**From:** Cruse & Associates <cruseandassoc@kvalley.com>  
**Sent:** Friday, March 15, 2013 8:41 AM  
**To:** Christina Wollman  
**Cc:** Jeff Watson  
**Subject:** Re: daugherty bla  
**Attachments:** KRD Permit.pdf

**From:** Christina Wollman  
**Sent:** Monday, January 07, 2013 10:49 AM  
**To:** Cruse & Associates ([cruseandassoc@kvalley.com](mailto:cruseandassoc@kvalley.com))  
**Subject:** daugherty bla

It looks like this BLA is to correct an encroachment onto the Umland property. Is it possible for you to show the actual driveway location on the "proposed" drawing?

PROPOSED BOUNDARY

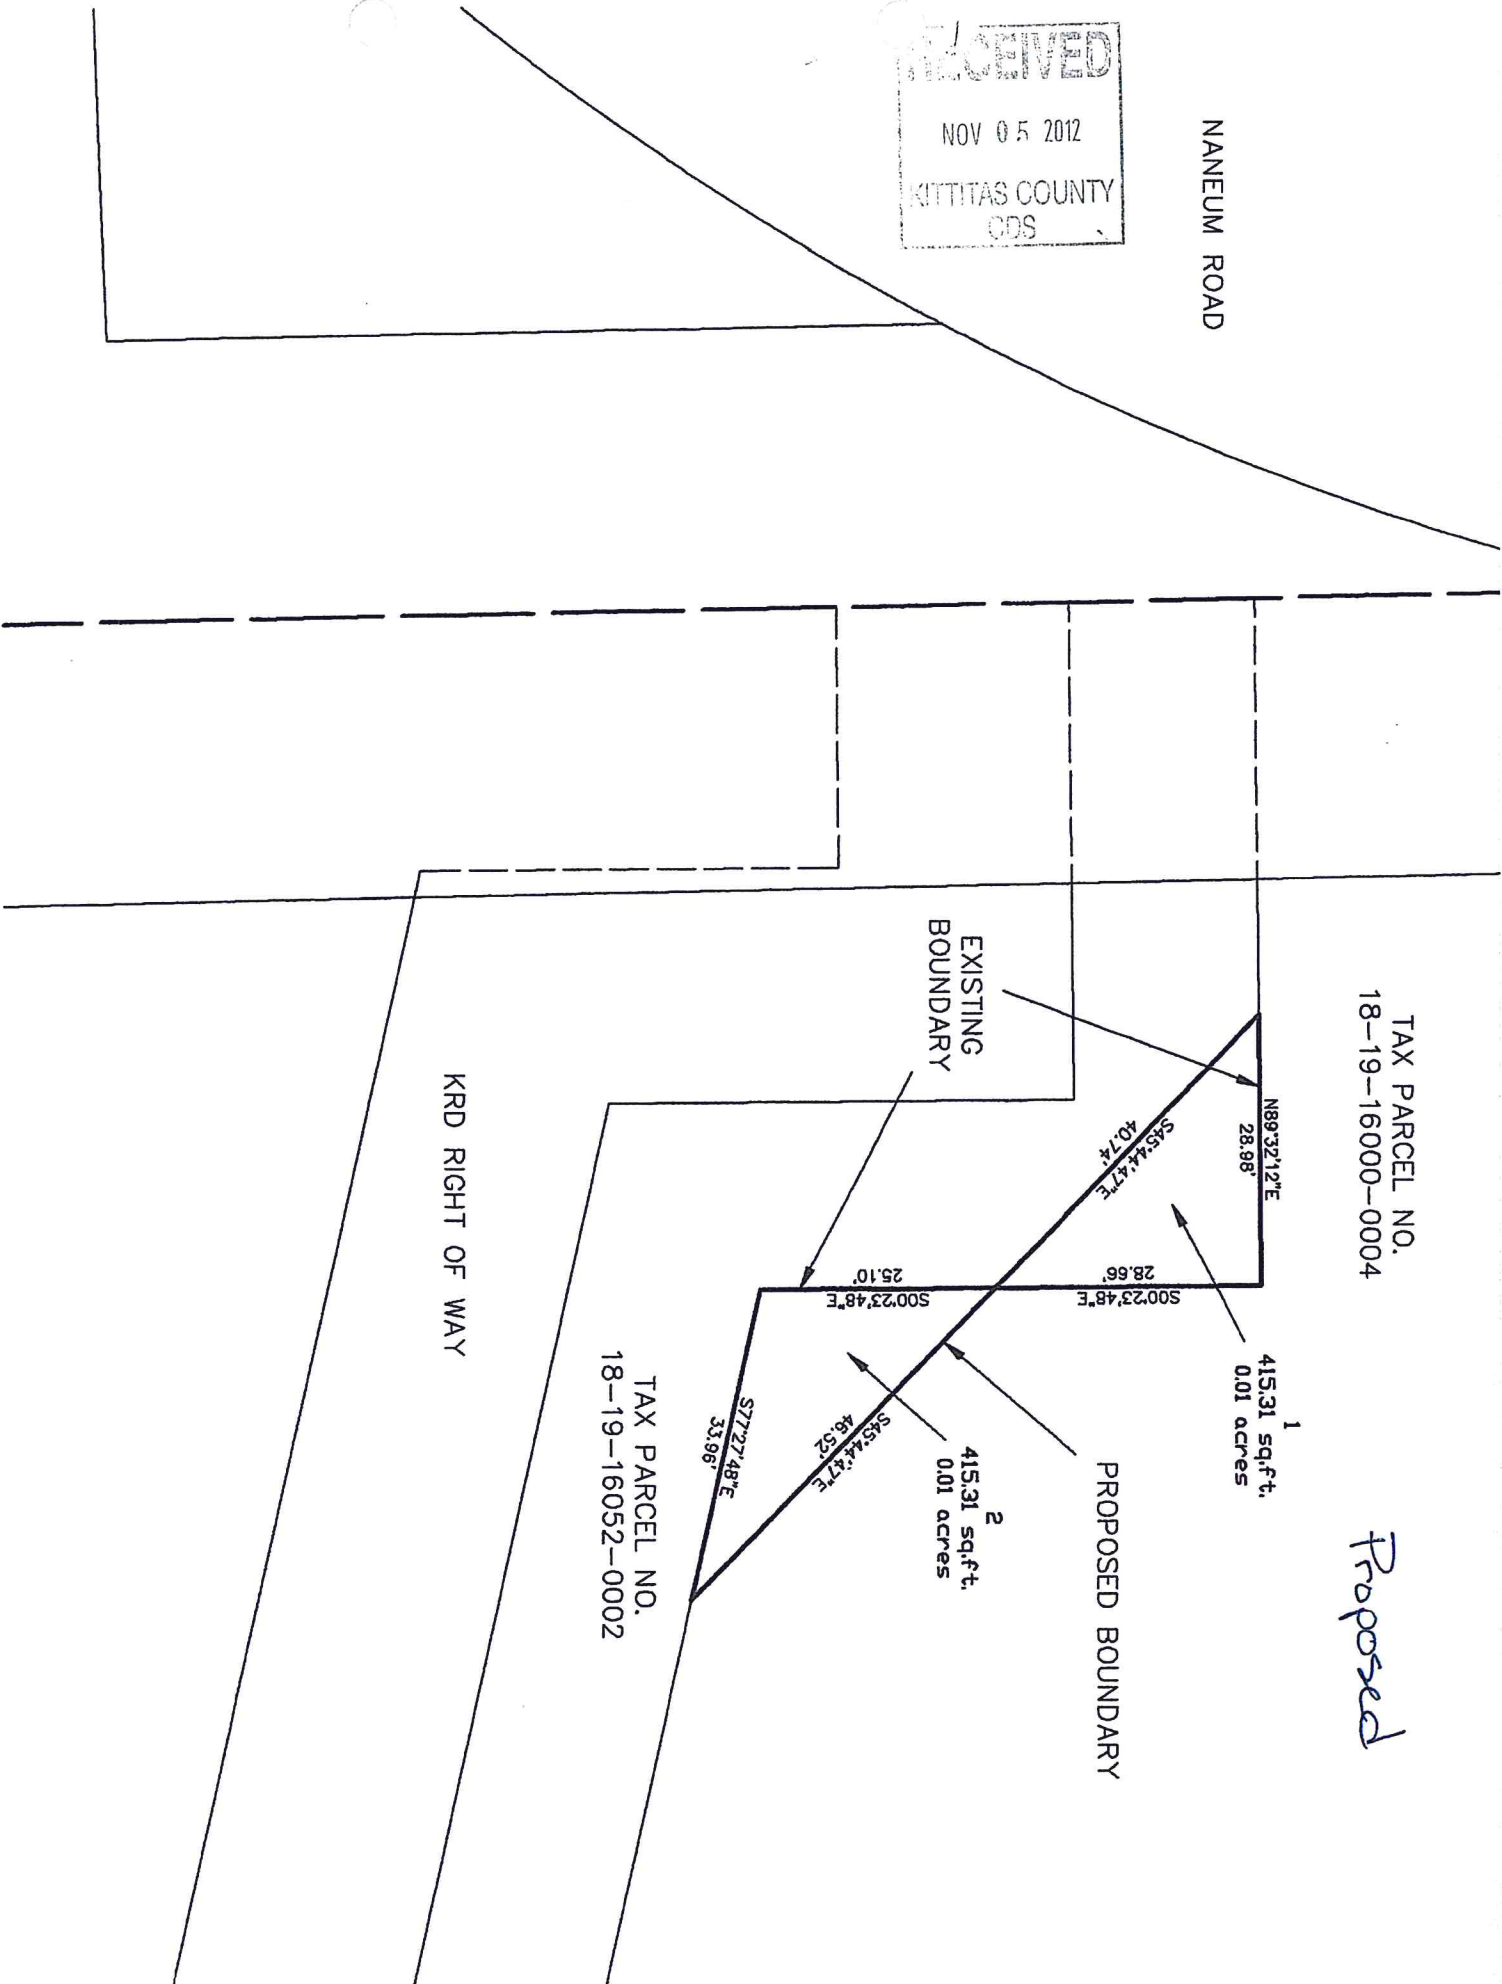
What is the distance between the KRD NE corner and the proposed boundary (see red line on attachment)? It look like it's only about 10'. I will not be able to approve this BLA with that narrow of width without an easement.

Daugherty dropped off his KRD crossing permit last night that shows the existing access. When the driveway was constructed it was straightened across the KRD to allow for access for larger trucks needed for construction.

It is 7.91' from the corner of the KRD r/w to the proposed boundary as you highlighted in red. Please review and contact me back with any questions.
